From: Amy Myer <Amy.Myer@arun.gov.uk>
Sent: 04 February 2020 10:43
To: Planning.Responses <Planning.Responses@arun.gov.uk>
Cc: Daniel Vick <Daniel.Vick@arun.gov.uk>
Subject: FW: AL/81/19/PL - D2 Paddock View - EXTENSION OF TIME

From: Amy Myer
Sent: 20 January 2020 16:33
To: [REDACTED]
Subject: AL/81/19/PL - D2 Paddock View - UPDATE

By way of an update on this application, this has been re-allocated to me from my colleague Simon, and I have now had chance to review the proposals.

SITE PLAN

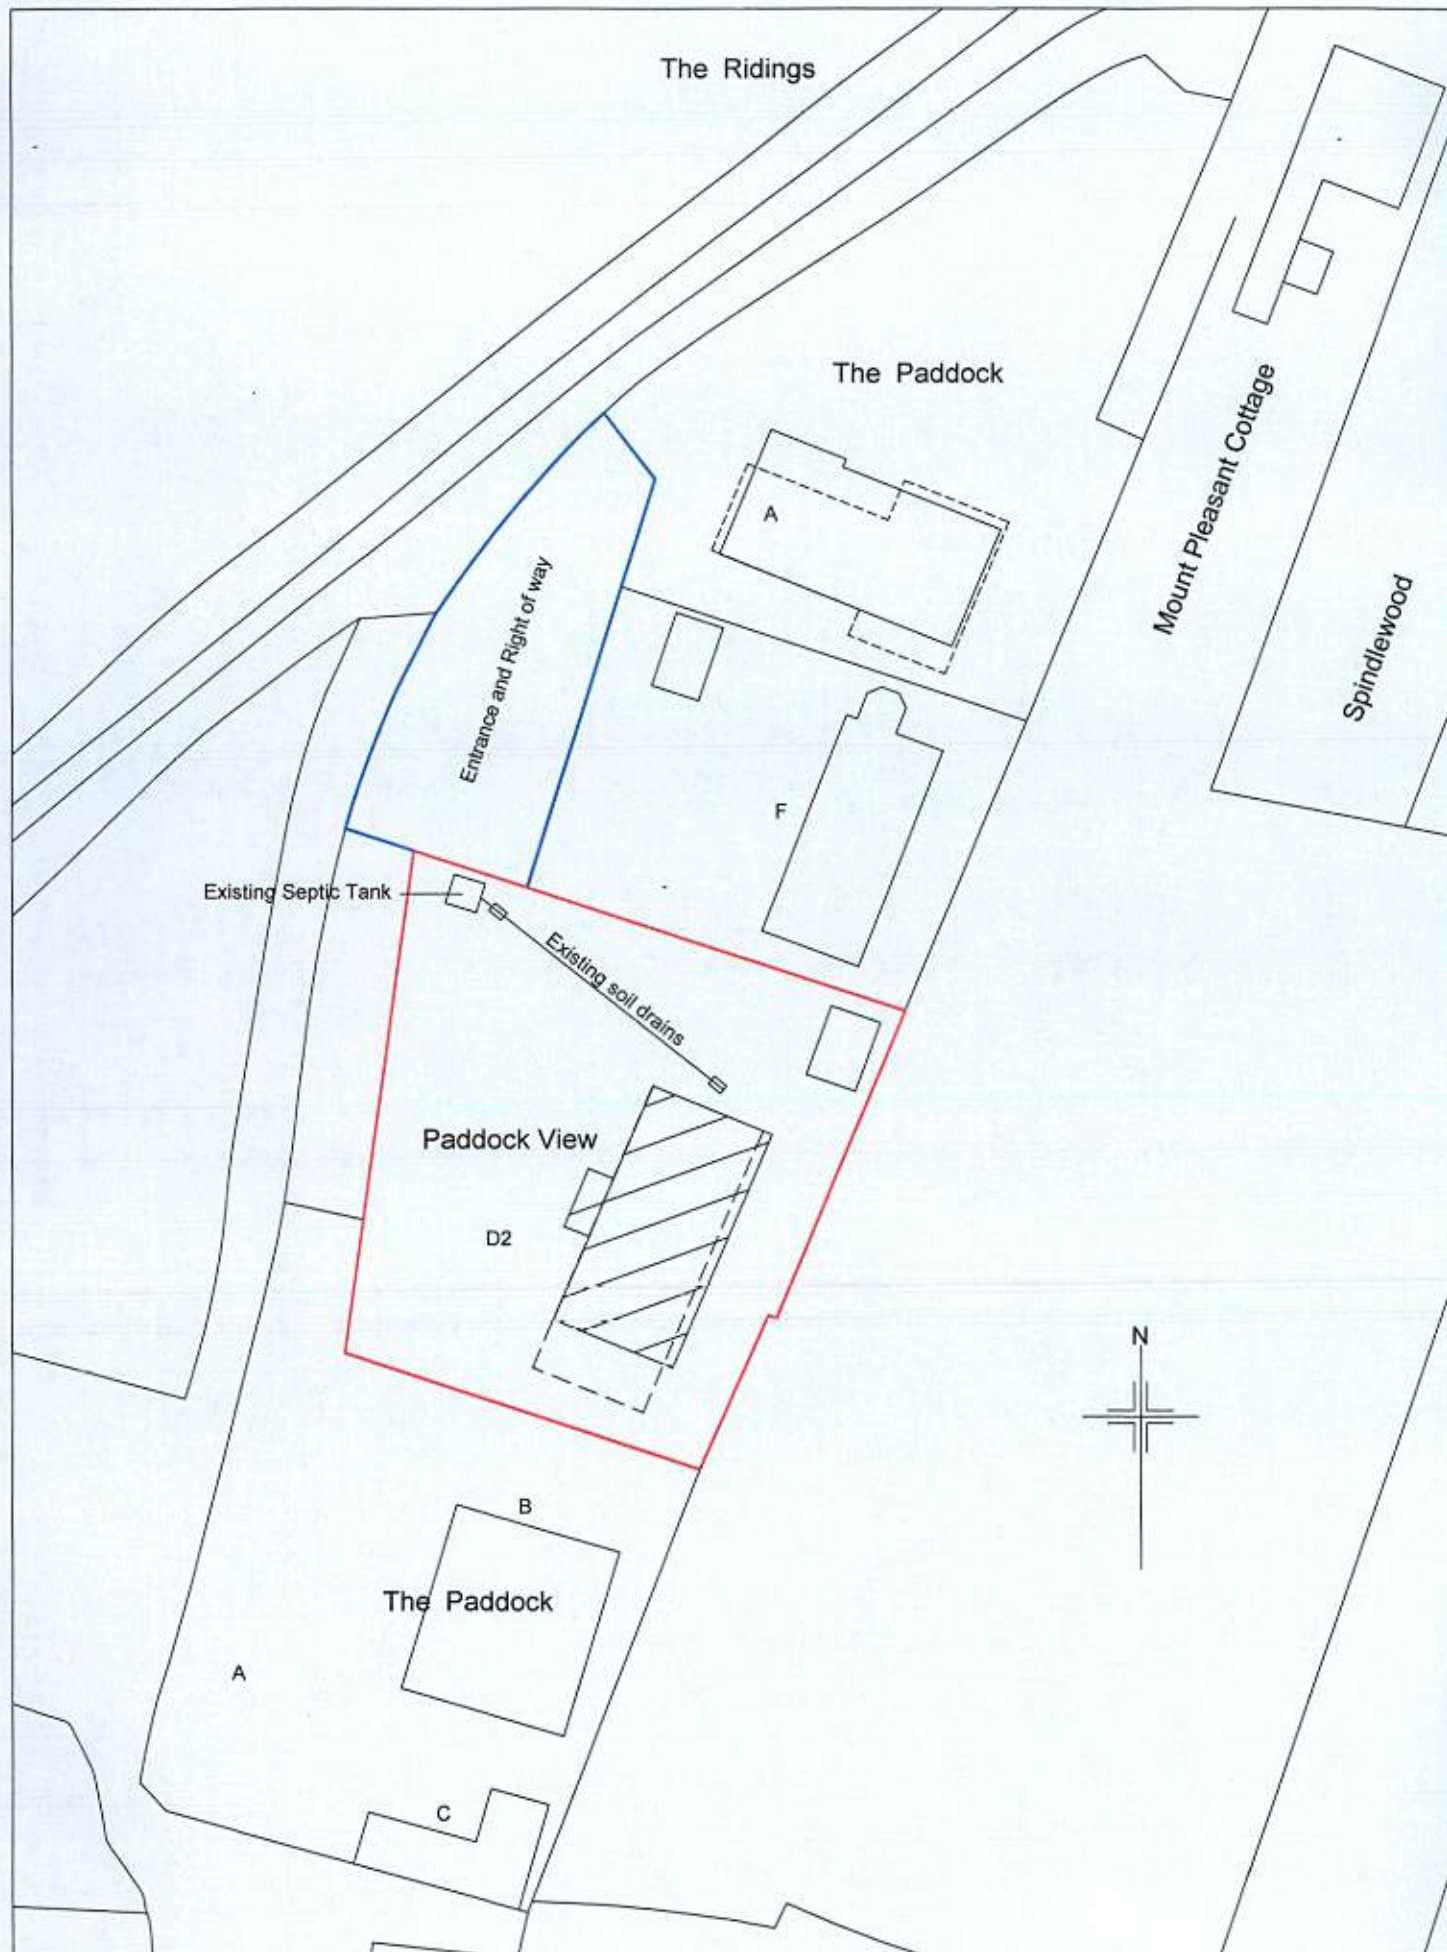
1. I noticed that there is a tree within the adjacent garden to Mount Pleasant Cottage, the Root Protection Area of which would likely be within influencing distance of the new foundations for the new dwelling. As this is a third party tree, it is probable I will need to consult the Council's Trees Officer and it may a Tree Protection Plan to show ground protection. I am just checking with the Trees Officer and will let you know as soon as I hear.
